Arun District Council
Arun Civic Centre
Maltravers Road
Littlehampton
West Sussex BN17 5LF
Planning & Building Control General Enquiries
Tel: (01903) 737756 Fax: (01903) 730442
Dx: 57406 Littlehampton
Minicom: 01903 732765
e-mail: planning@arun.gov.uk
website: www.arun.gov.uk/planning

Application No: P/159/21/PL
Site Address: 253-255 Inglenook Hotel Pagham Road Pagham PO21 3QB
Description of works: Variation and removal of conditions imposed under P/58/19/PL for the variation of condition 2-plans condition & 16-external lighting of roads & footpaths & removal of conditions 11-footpath access through Hotel site & 13-signage of vehicular access previously proposed.

Thank you for your internet representation made on 20th December 2021 which has been recorded as an objection with the comments as follows:

Drawing Status	Draft		
Client	ADM Architects		
Project	Inglenook Hotel, Pagham		
Drawing Title	Car Parking Swept Path Analysis		
Scale	Date	Drawn By	Checked By
1:250	June 21	SMO	ALB
Drawing No.	2020-6289-005		Rev. B

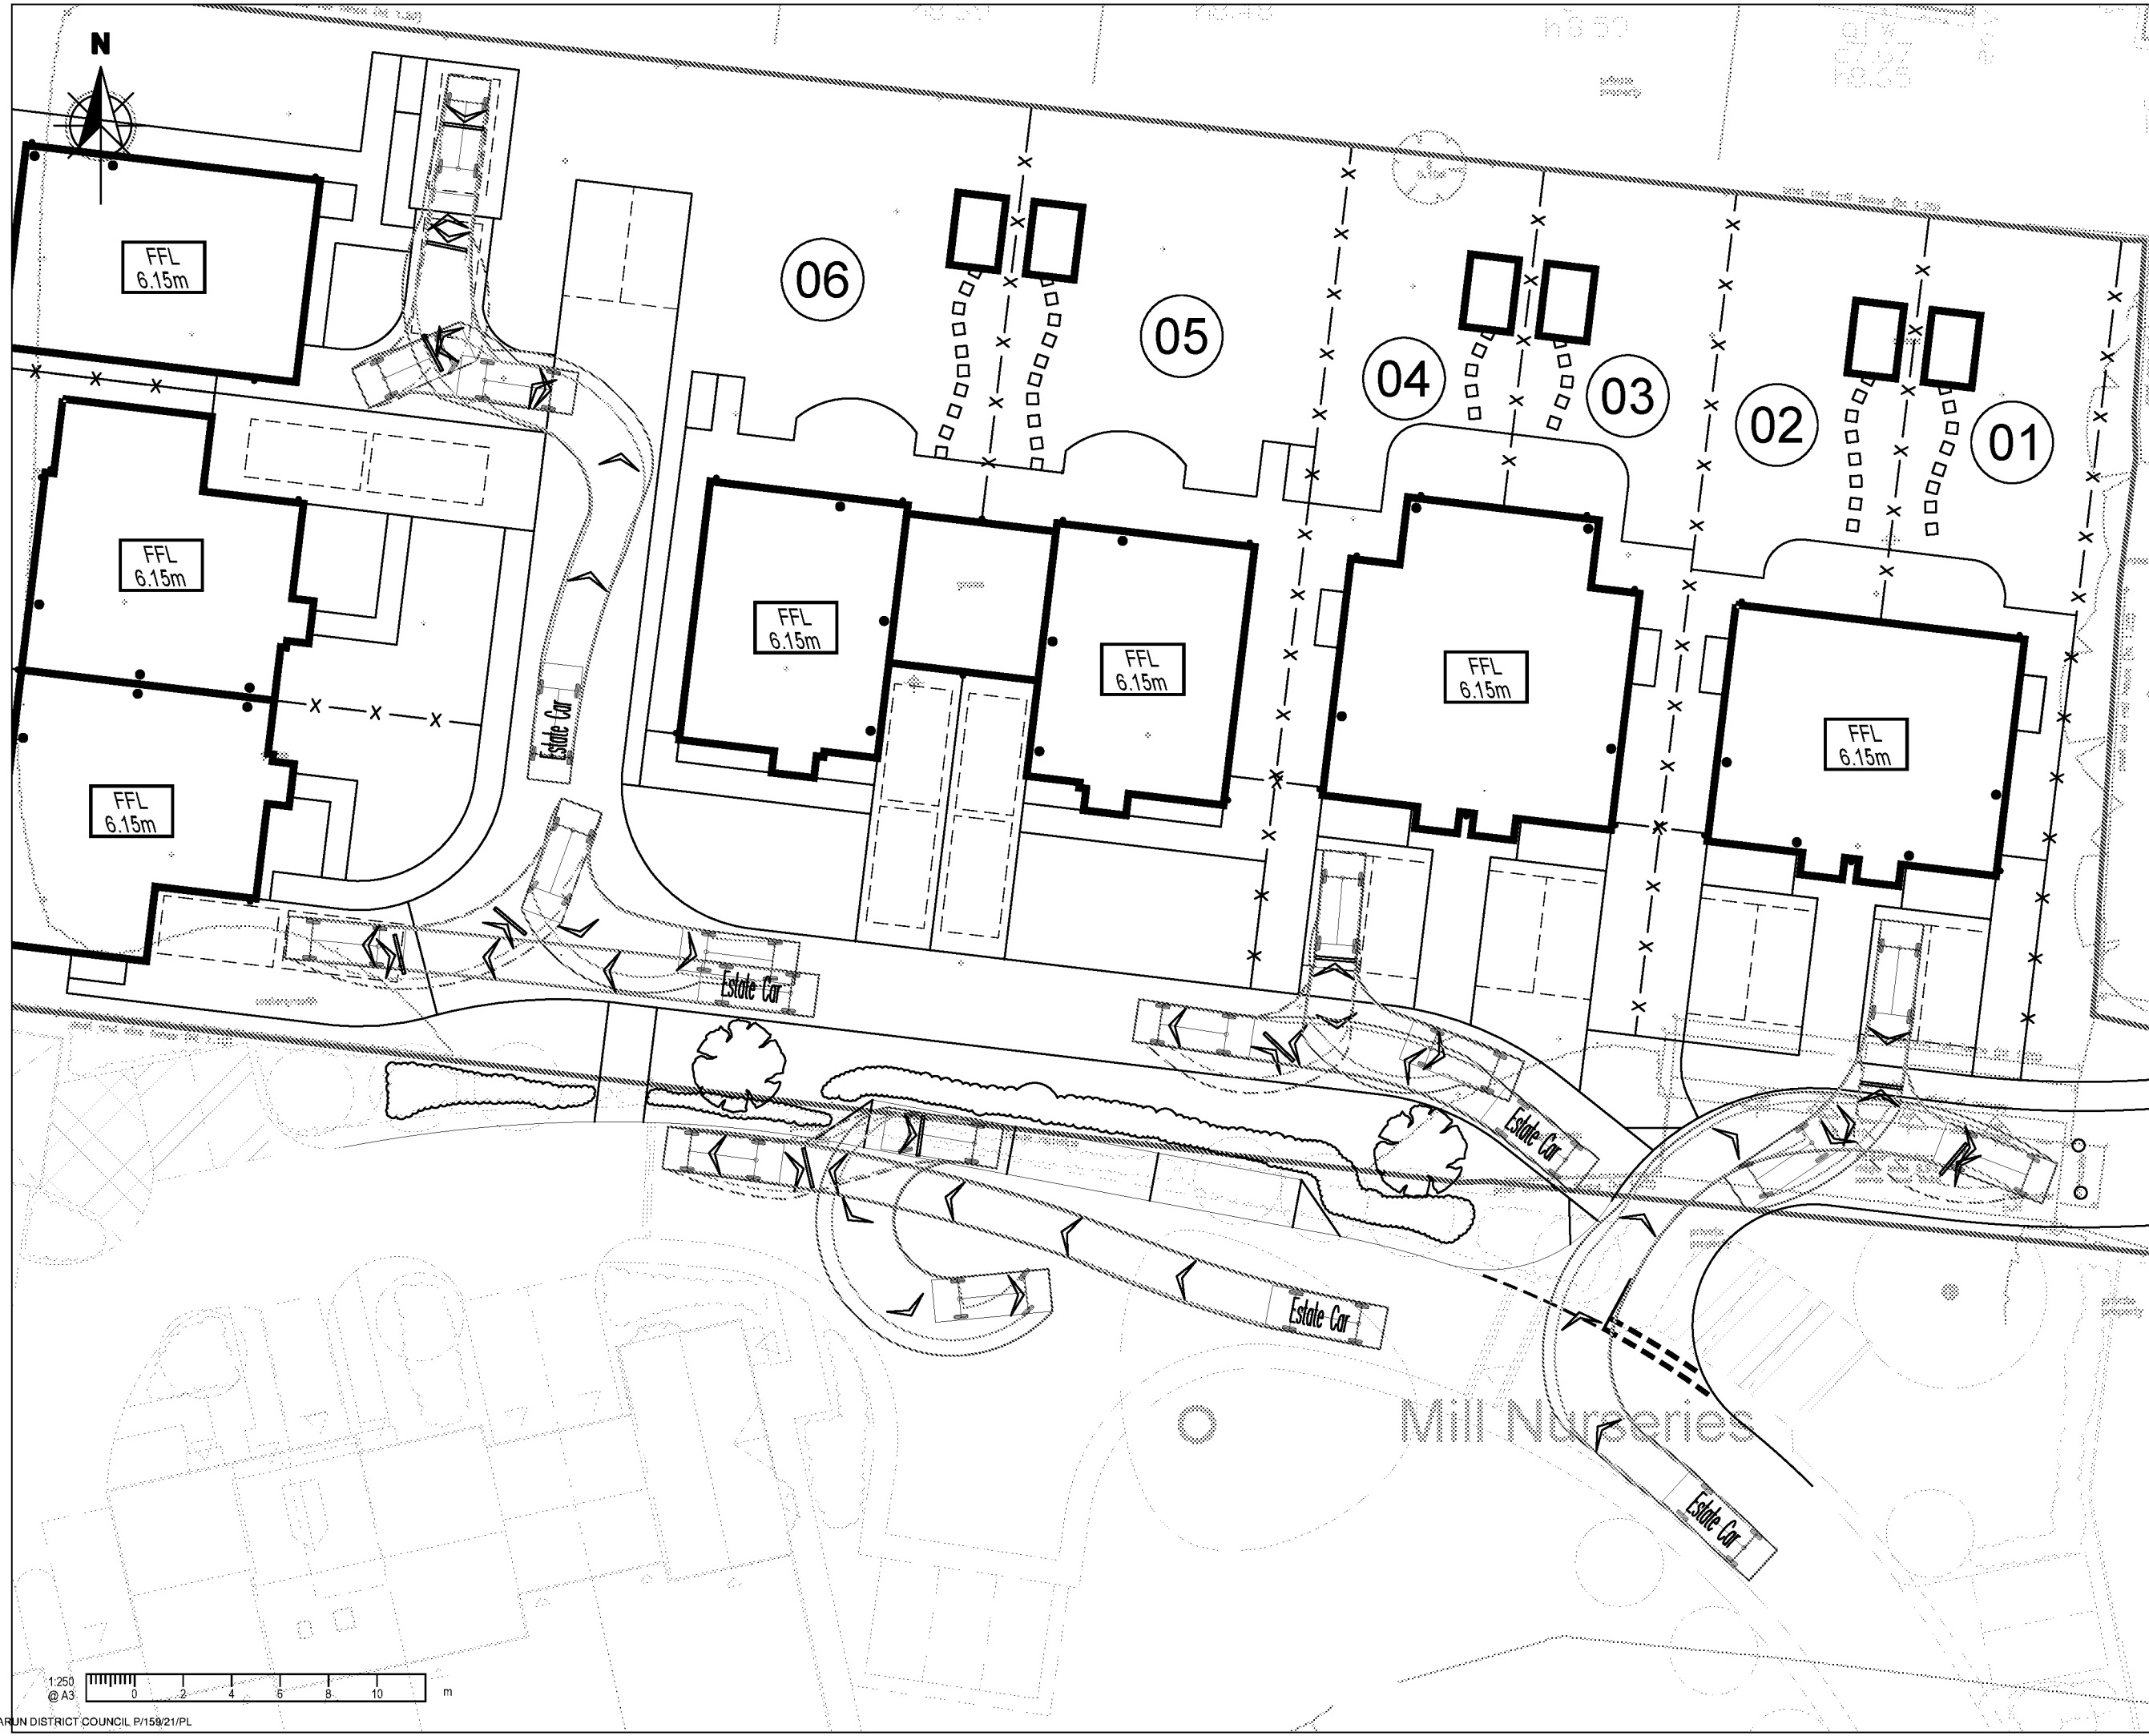
The increase in bedrooms and square footage for 4 of the dwellings increases the requirement for additional parking which was already short by 4 spaces and which will now be increased to 8. Although a revised plan has provided an additional 4 spaces on site there remains a shortfall of 4. There is no parking available in the village and any parking shortfall is unacceptable. It should not be assumed that other developments parking allocations should meet this shortfall who are already providing their quota of parking. Spinnaker View is adhering to their developments Condition 14 . 'to ensure the 4 proposed visitor parking spaces are promoted and available for general public use- .The approved measures shall thereafter be implemented and permanently retained/maintained. Reason: To ensure compensatory parking for the wider public and to accord with policies GEN7 & GEN12 of the ADC Local Plan. These spaces were provided by the developers of Spinnaker View for the use of the village in mitigation for the loss of public parking spaces on the Pagham Road
